Application No: AB/129/21/HH
Site Address: Fern Cottage 5A Surrey Street Arundel BN18 9DT
Description of works: Loft conversion to habitable use with 1 x rear dormer including the installation of 2 x front conservation rooflights. (This application may affect the character and appearance of the Arundel Conservation Area).

Thank you for your internet representation made on 26th November 2021 which has been recorded as an objection with the comments as follows:

OWPC42201

Existing West Elevation

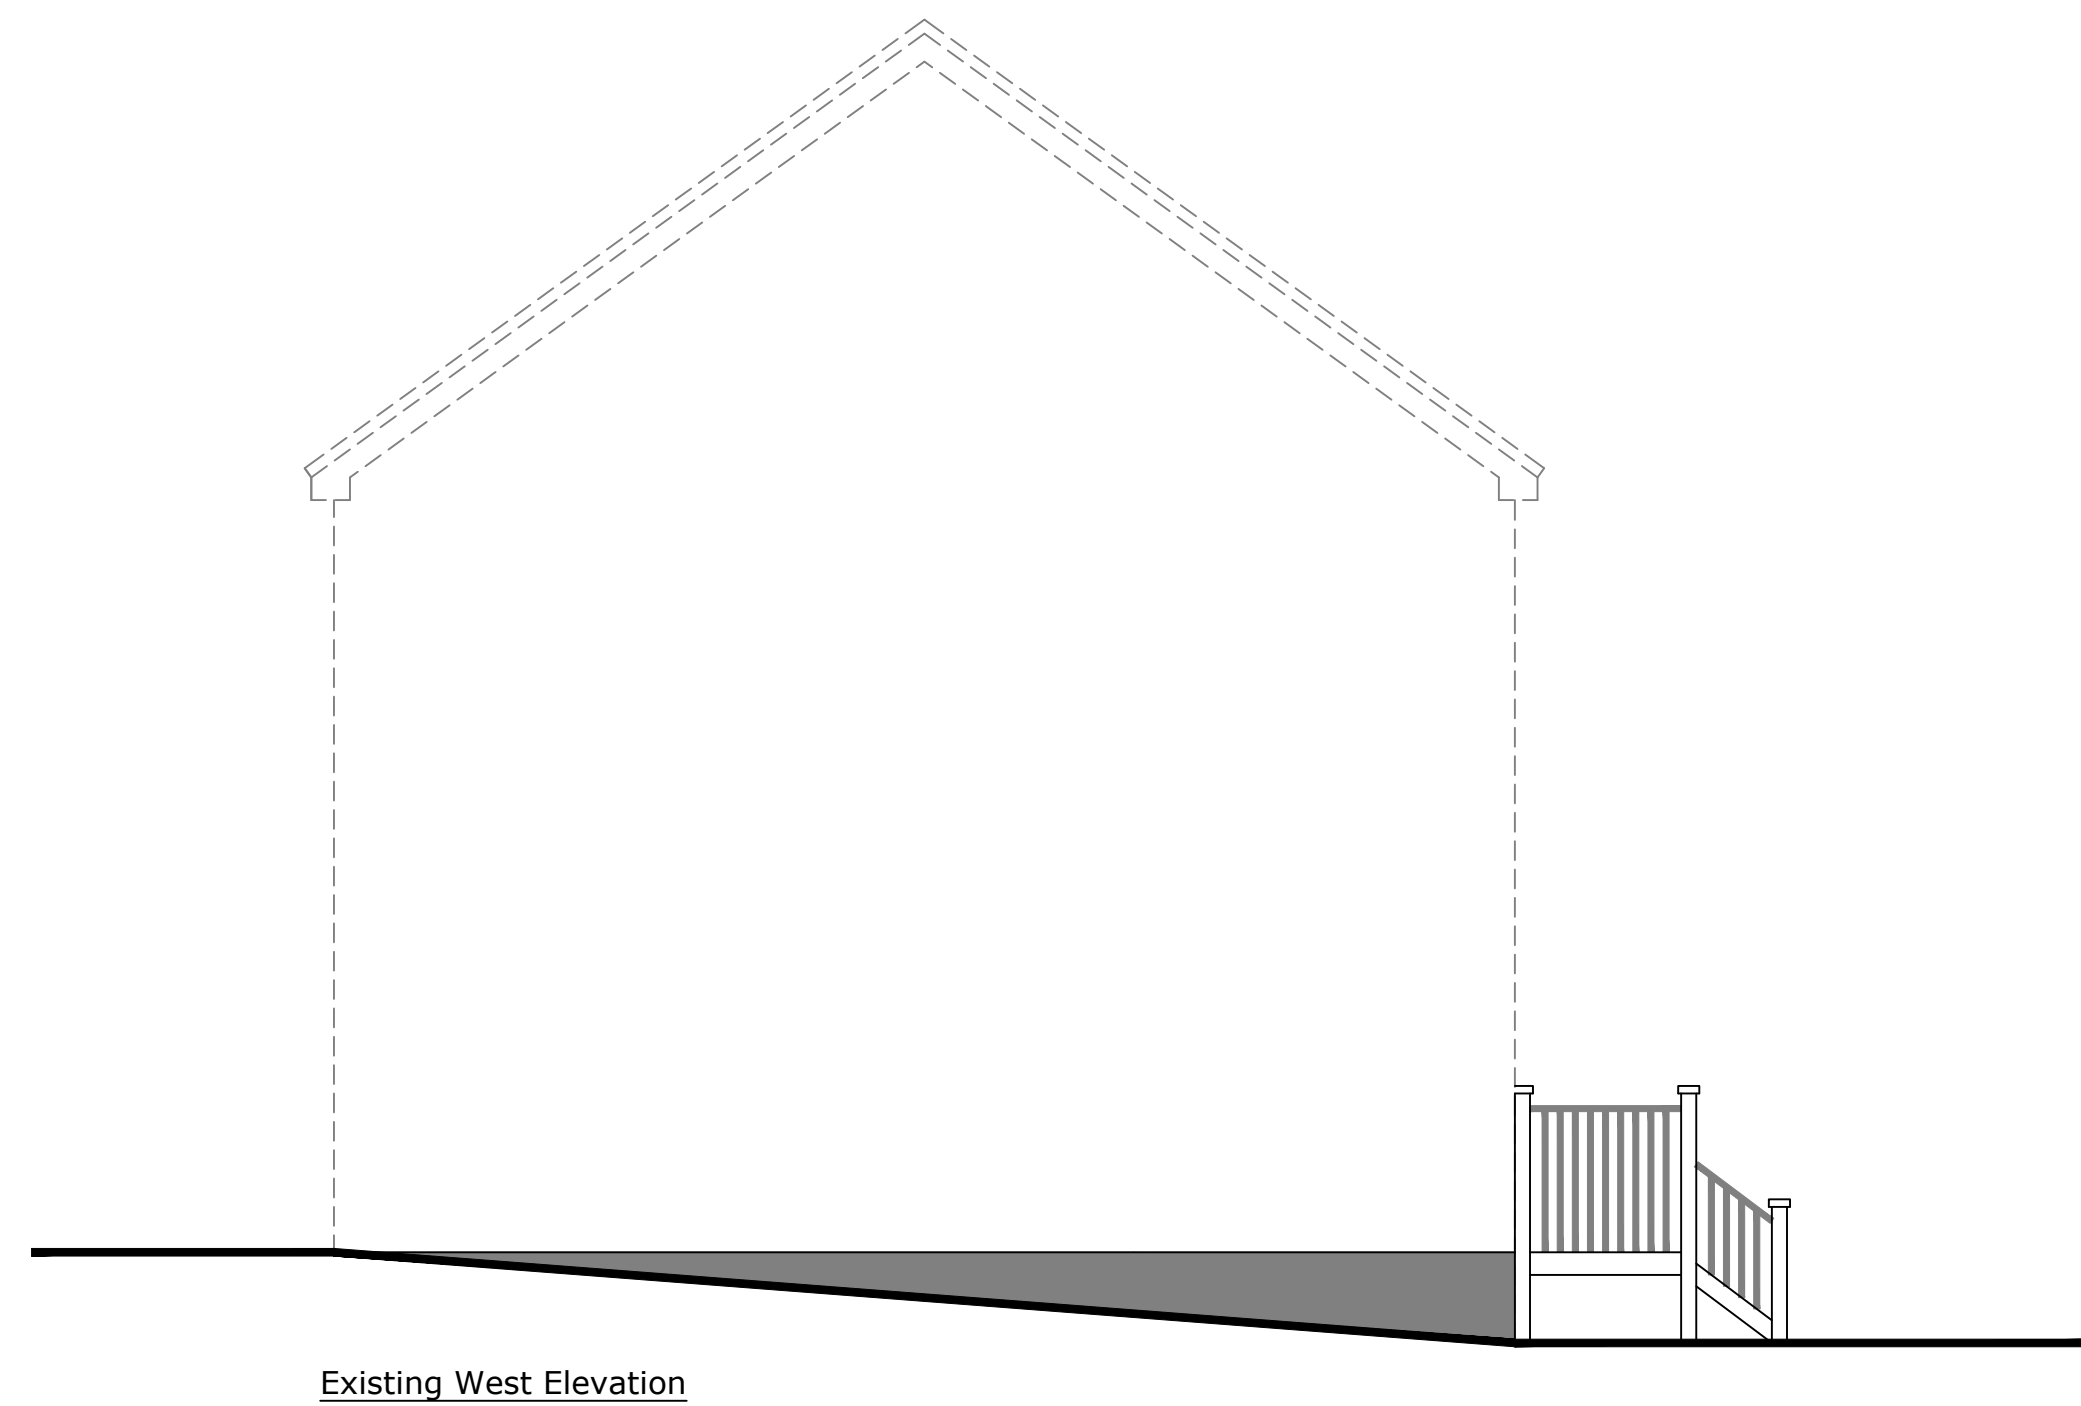
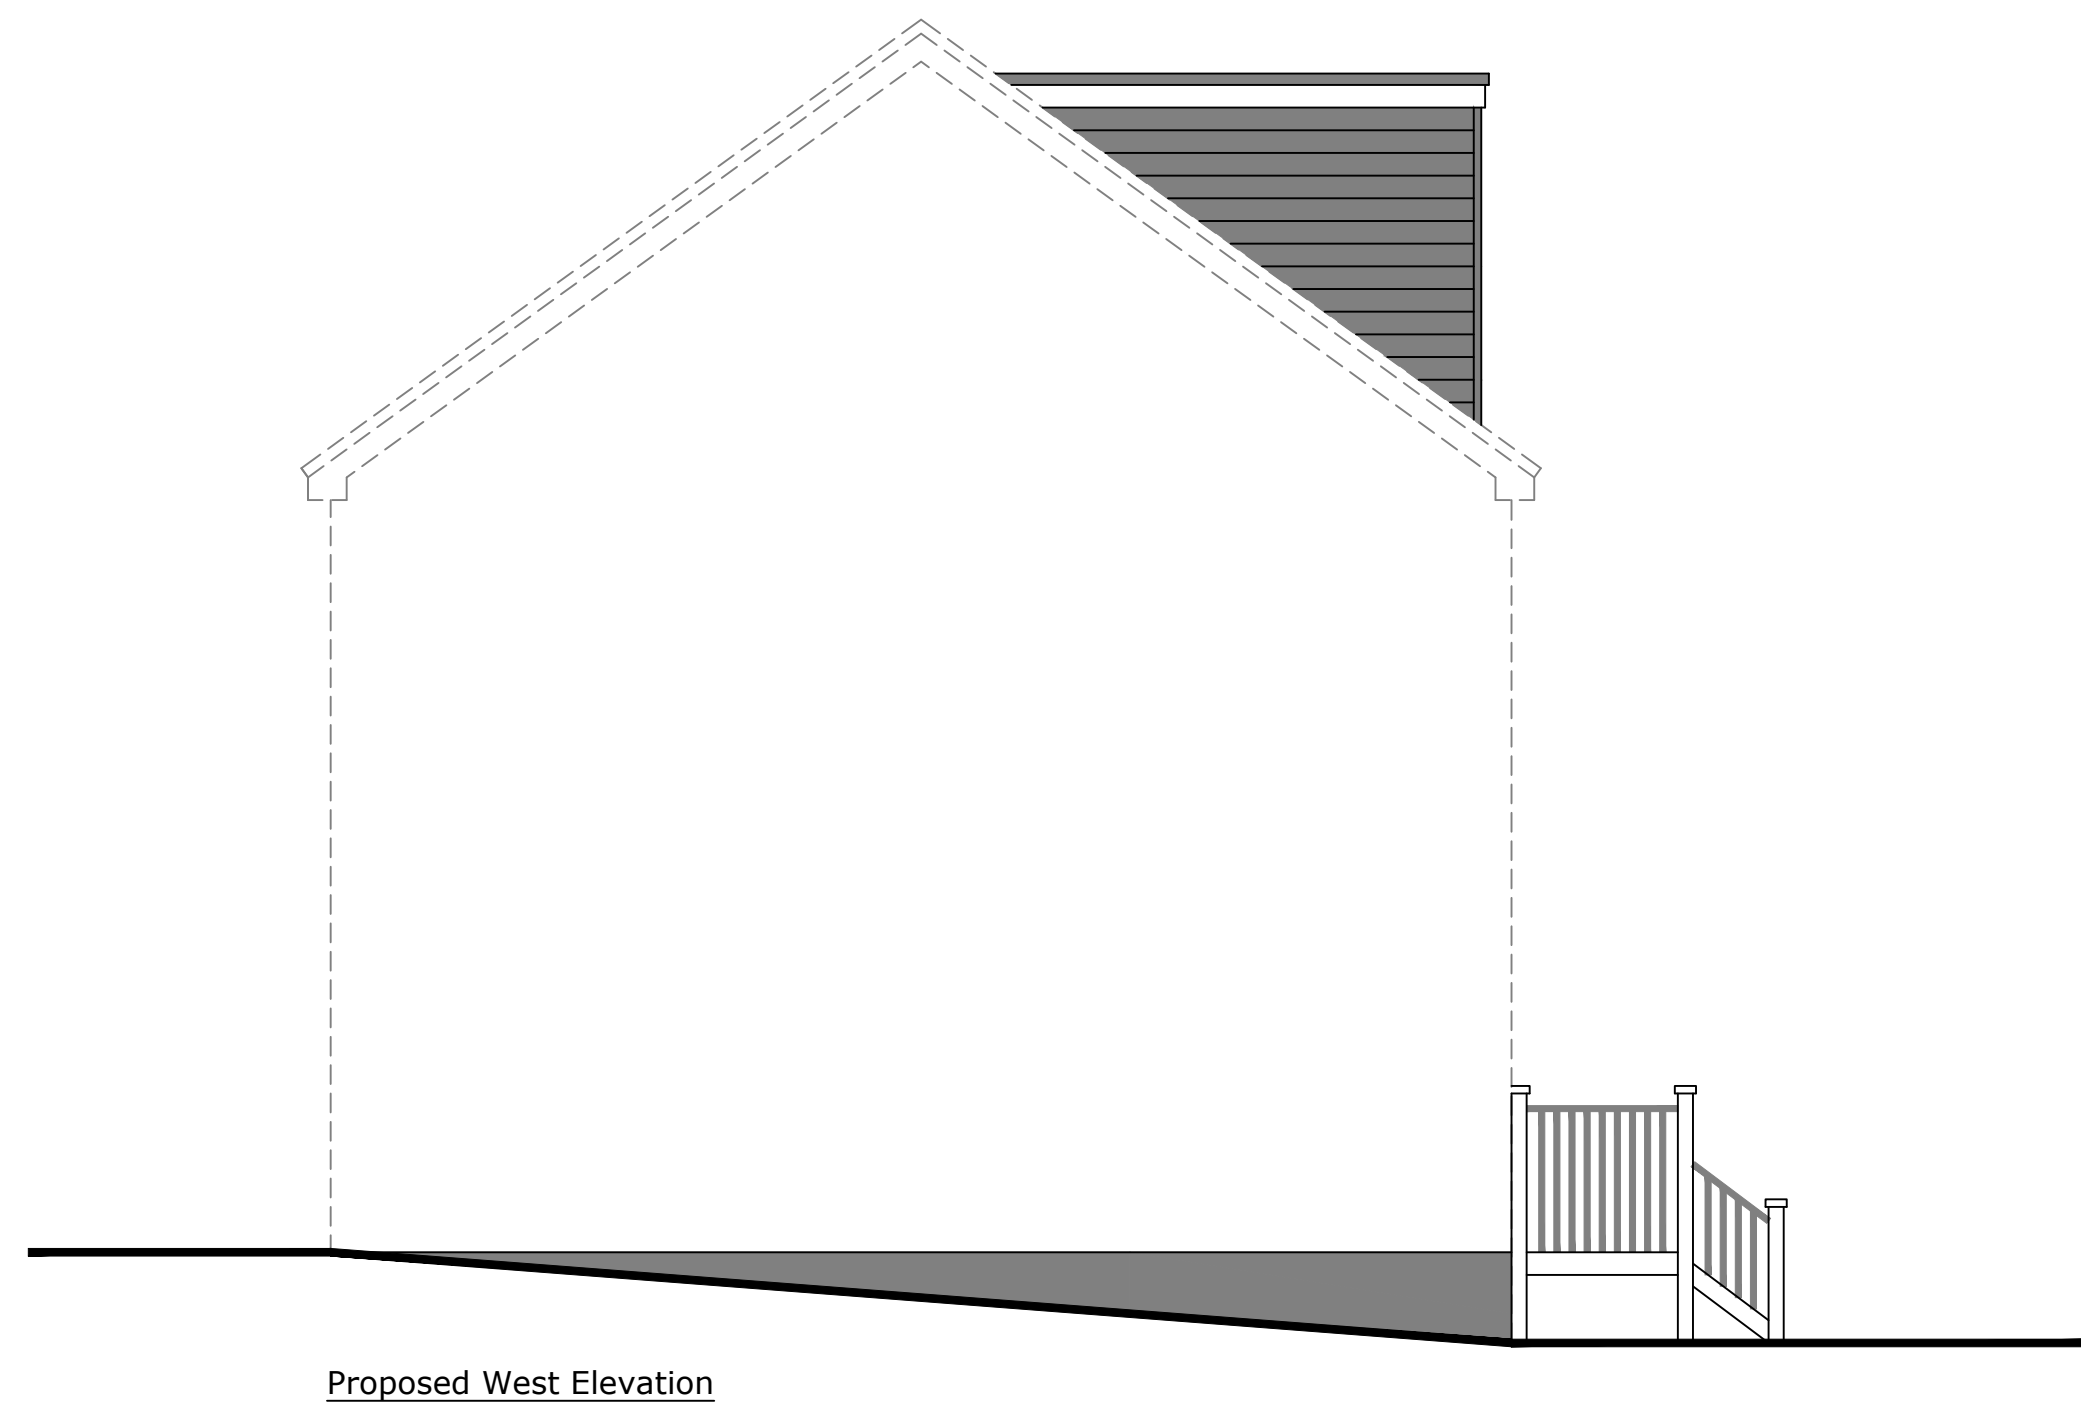
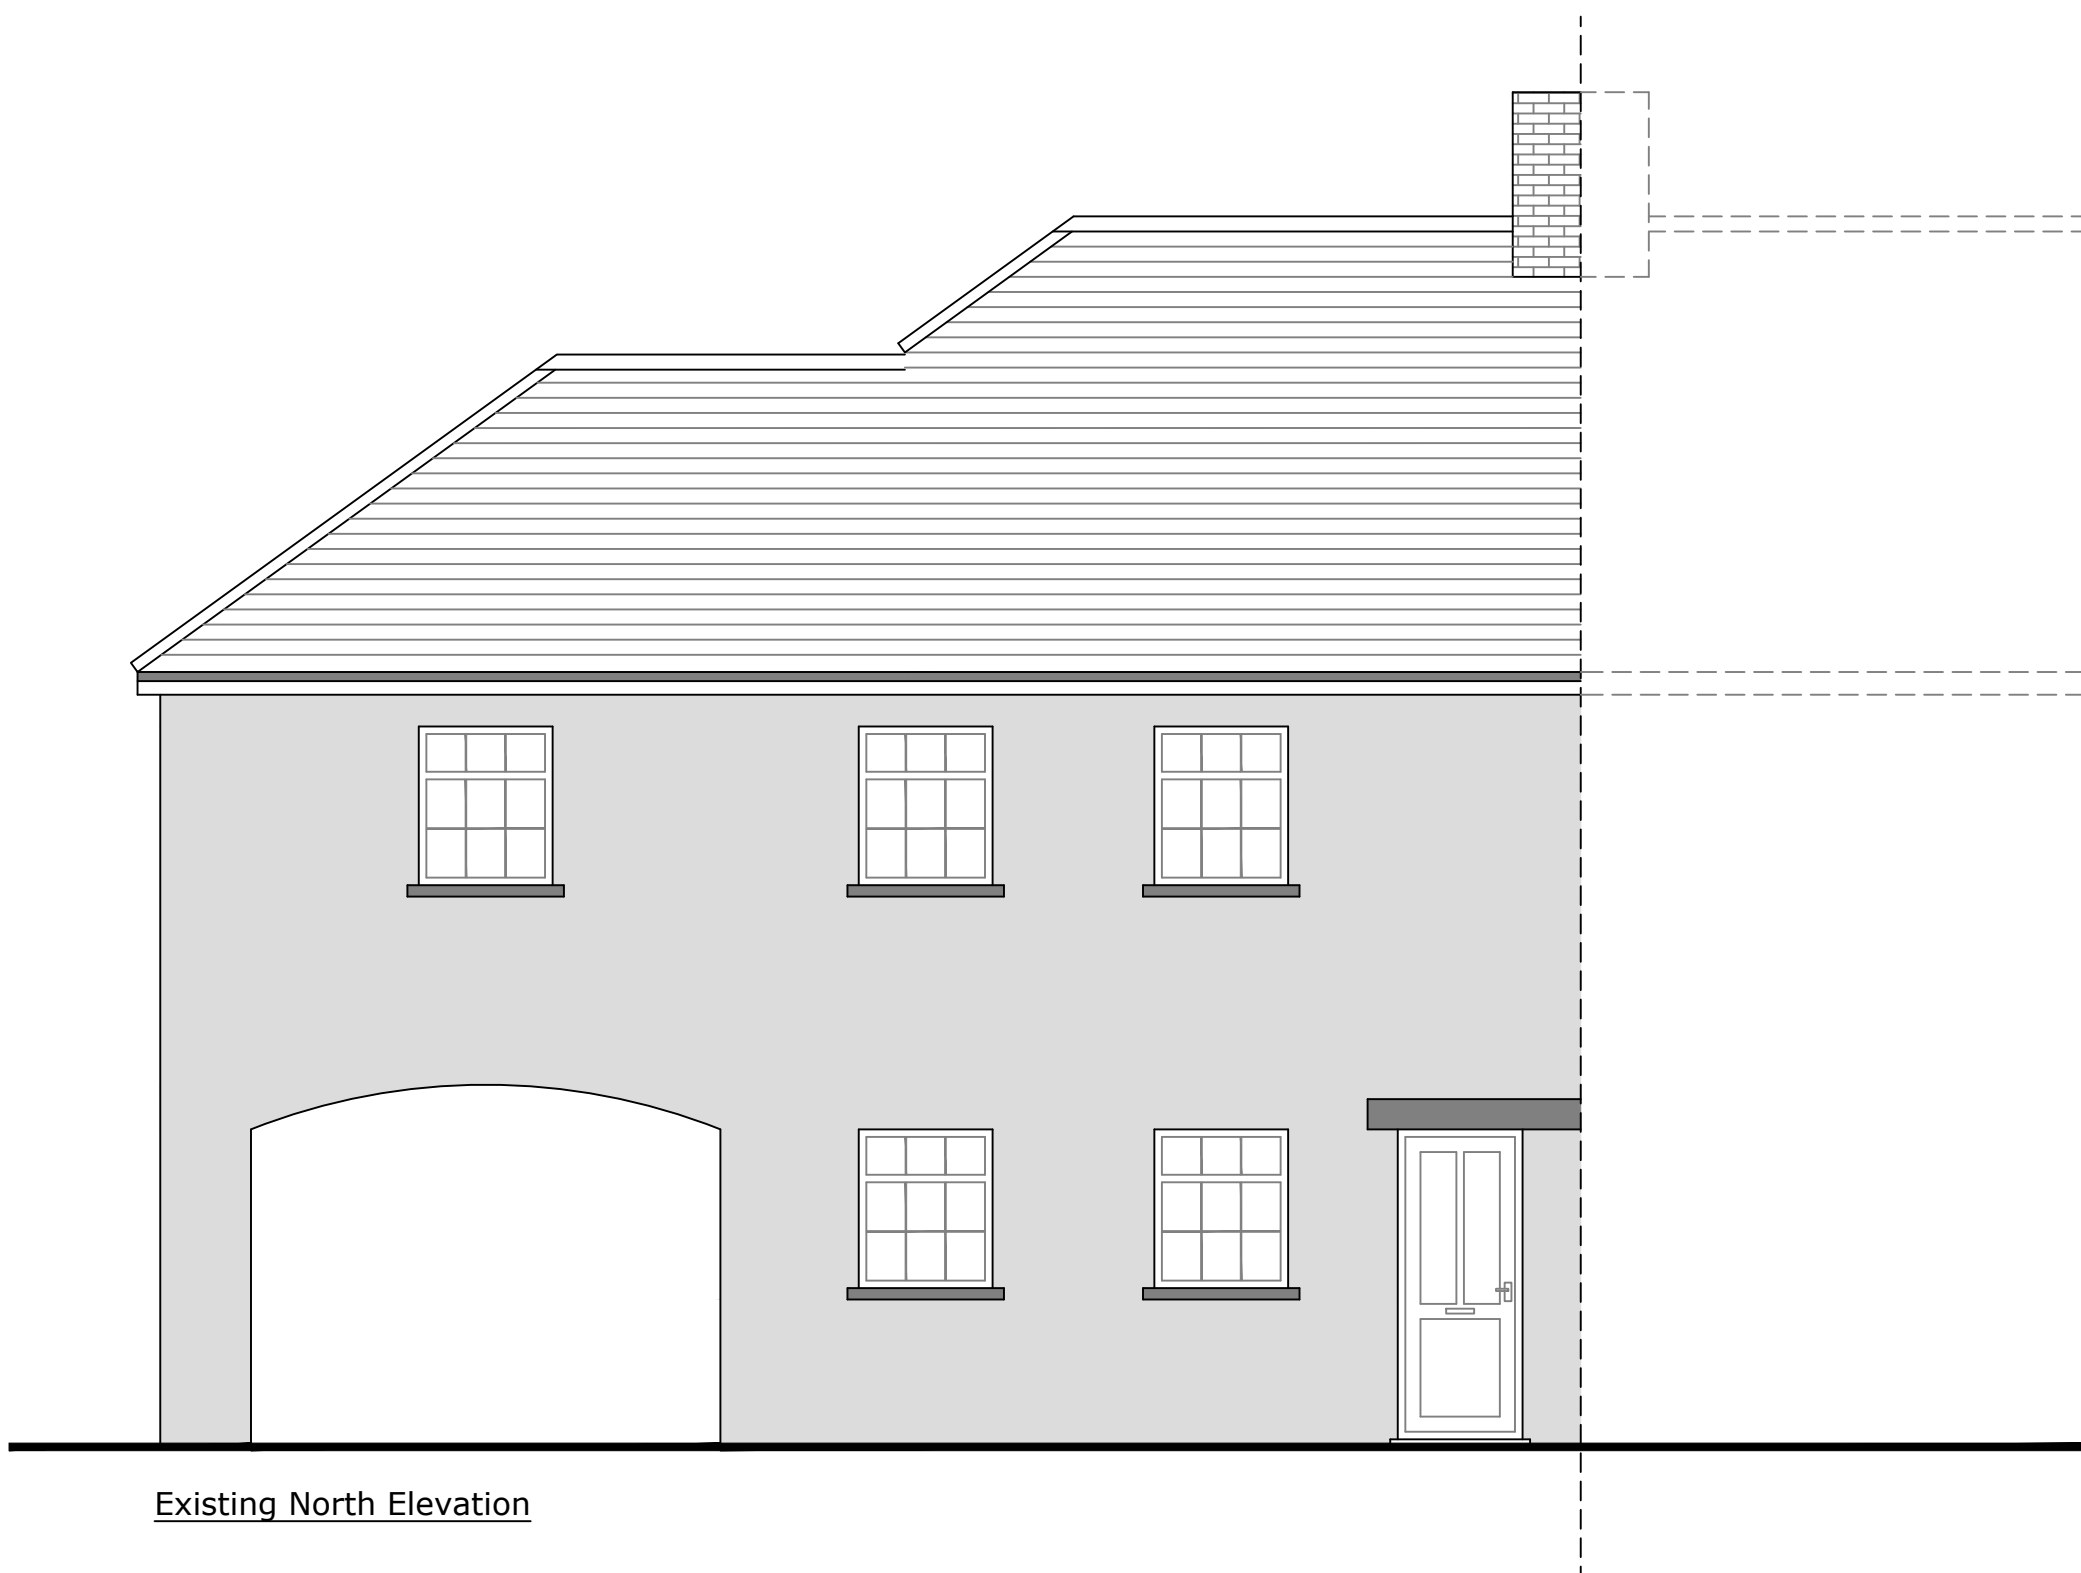
On the rear elevation a very large dormer extension is still proposed but which does not now involve a change in the existing roof profile as viewed from Surrey Street and School Lane. It is unlikely that the extension will be readily viewed from Surrey Street or The Slupe but that requires a detailed assessment by ADC.
